From: Susan Leeson
Sent: 10 April 2012 13:44
To: [REDACTED]
Cc: 'Richard Pierce'
Subject: RE: P/92/11/DOC (Discharge of Conditions)

Butterlees Barn, Butterlees Farm, LAGNESS
Application P/145/08 – Discharge of Conditions

BUTTERLEES BARN - LHAGNESS
SITE PLAN AS PROPOSED
DWG: BUT/D-01F 1:200 @ A3 JUL 2008
MALCOLM SIMMONDS ARCHITECTS

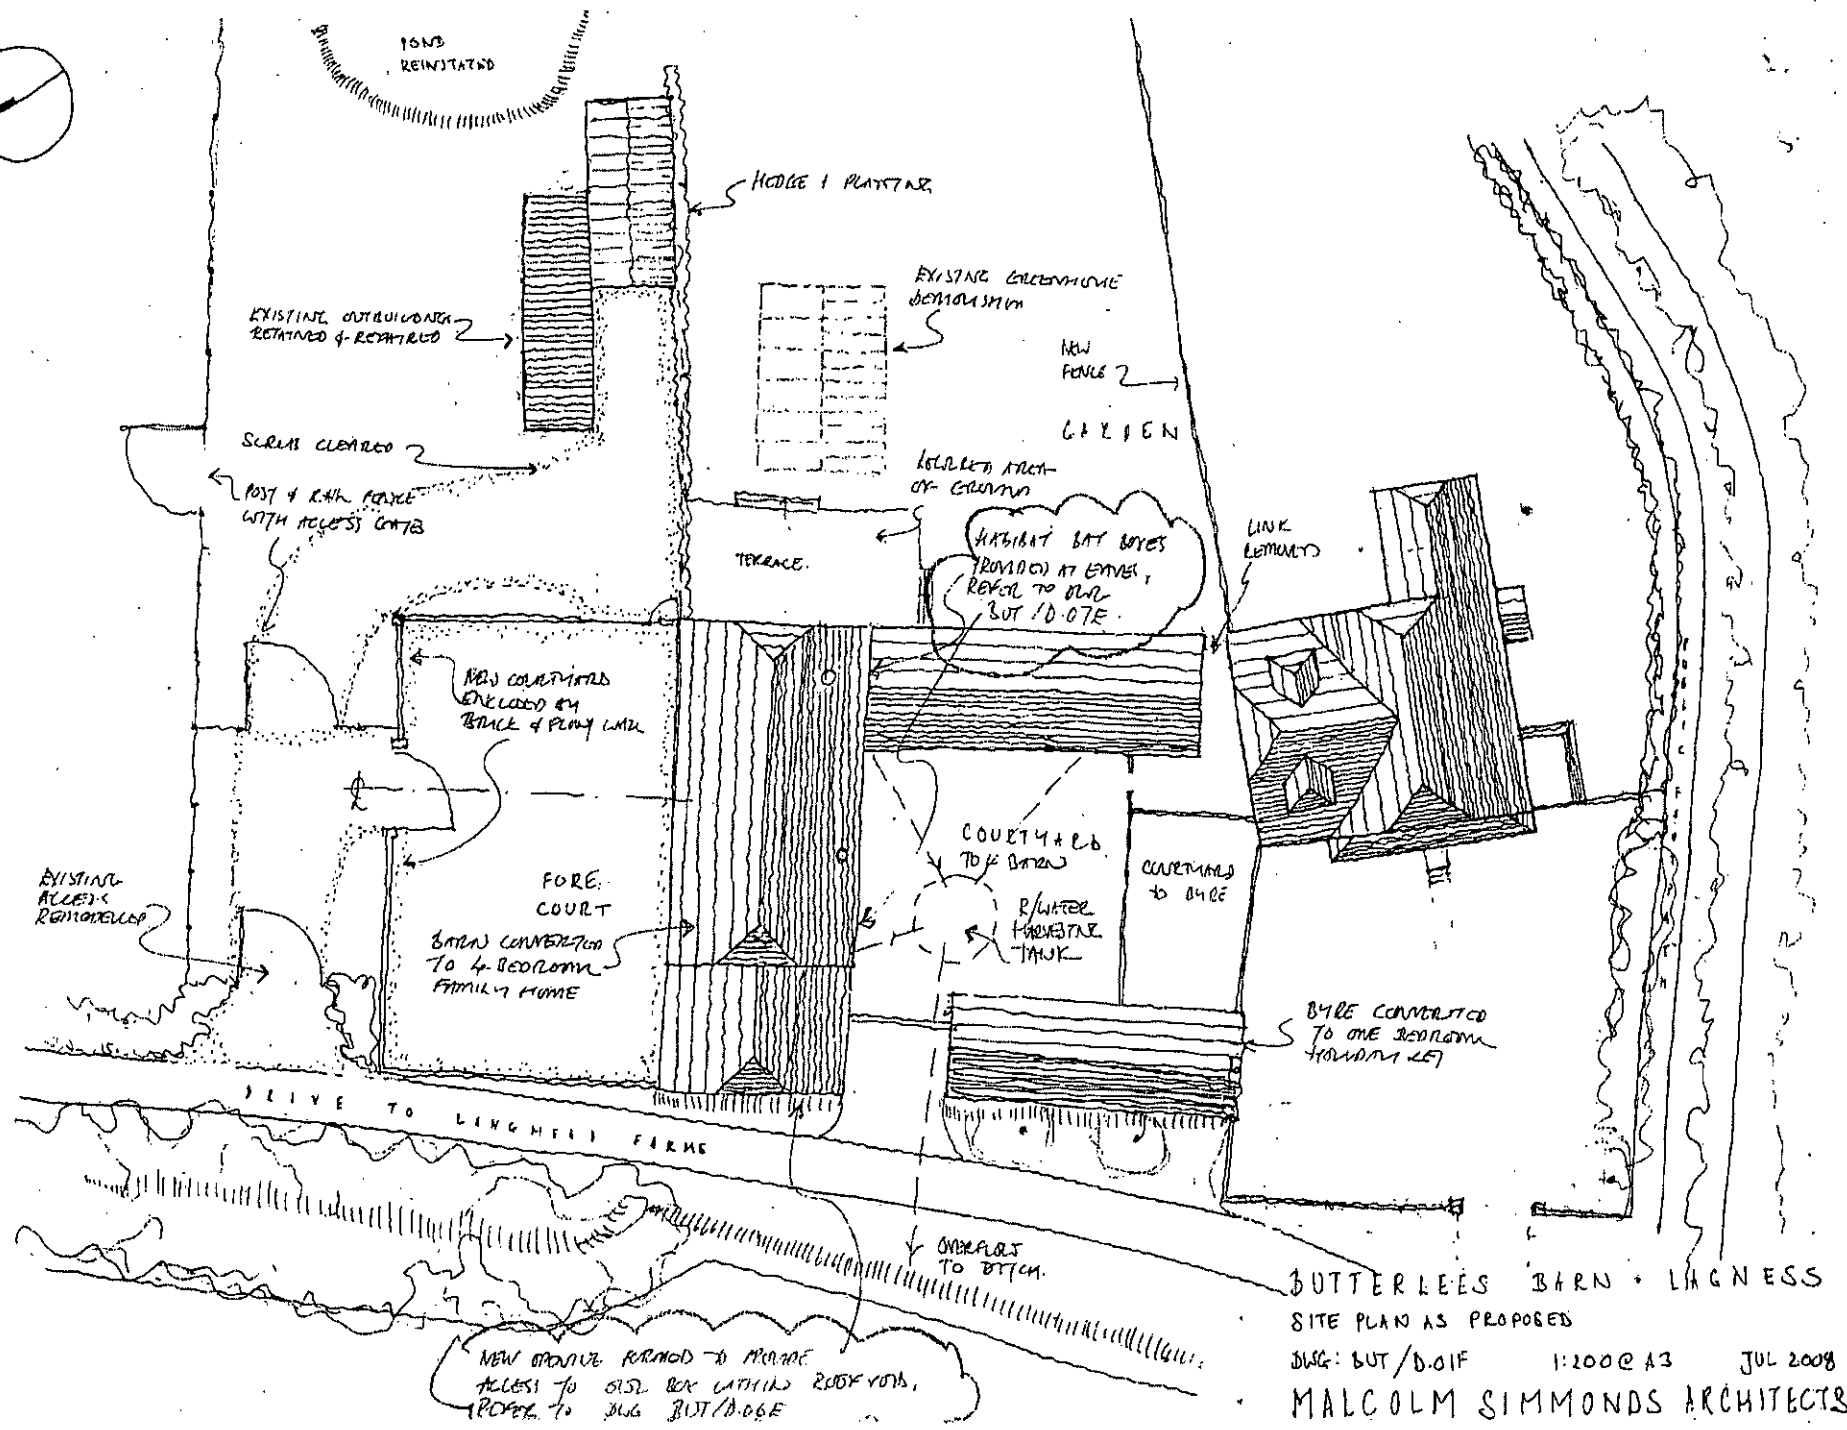
Thanks for the additional information. The locations for the bat boxes and the owl box seem appropriate. One would normally expect greater detail in terms of the design of the owl loft rather than simply a proposal to install an owl box in the roof void. Figs. 2 & 3 in attached Natural England guidance show how an owl loft can be created. If the applicant can commit to a similar design, I would then discharge the condition.

I note that Don, in his comments of 6th Feb 2012, recommended access and nesting provision (e.g. Schwegler No. 10 nestbox) should be provided for Swallows. Maybe this wasn't conditioned.

Further to your recent emails, please find enclosed our revised drawings showing Bat and Owl Box positions as requested and we apologise for the delay in getting these to you.

In summary, two bat boxes have been provided on the preferred south west elevation, these would be Habitat Bat Boxes with a custom brick facing to match the existing building. the owl box would be located on the south west corner of the building facing open fields and built into the building to provide the sort of shelter that Owl's prefer as well as be a discreet addition to the building.
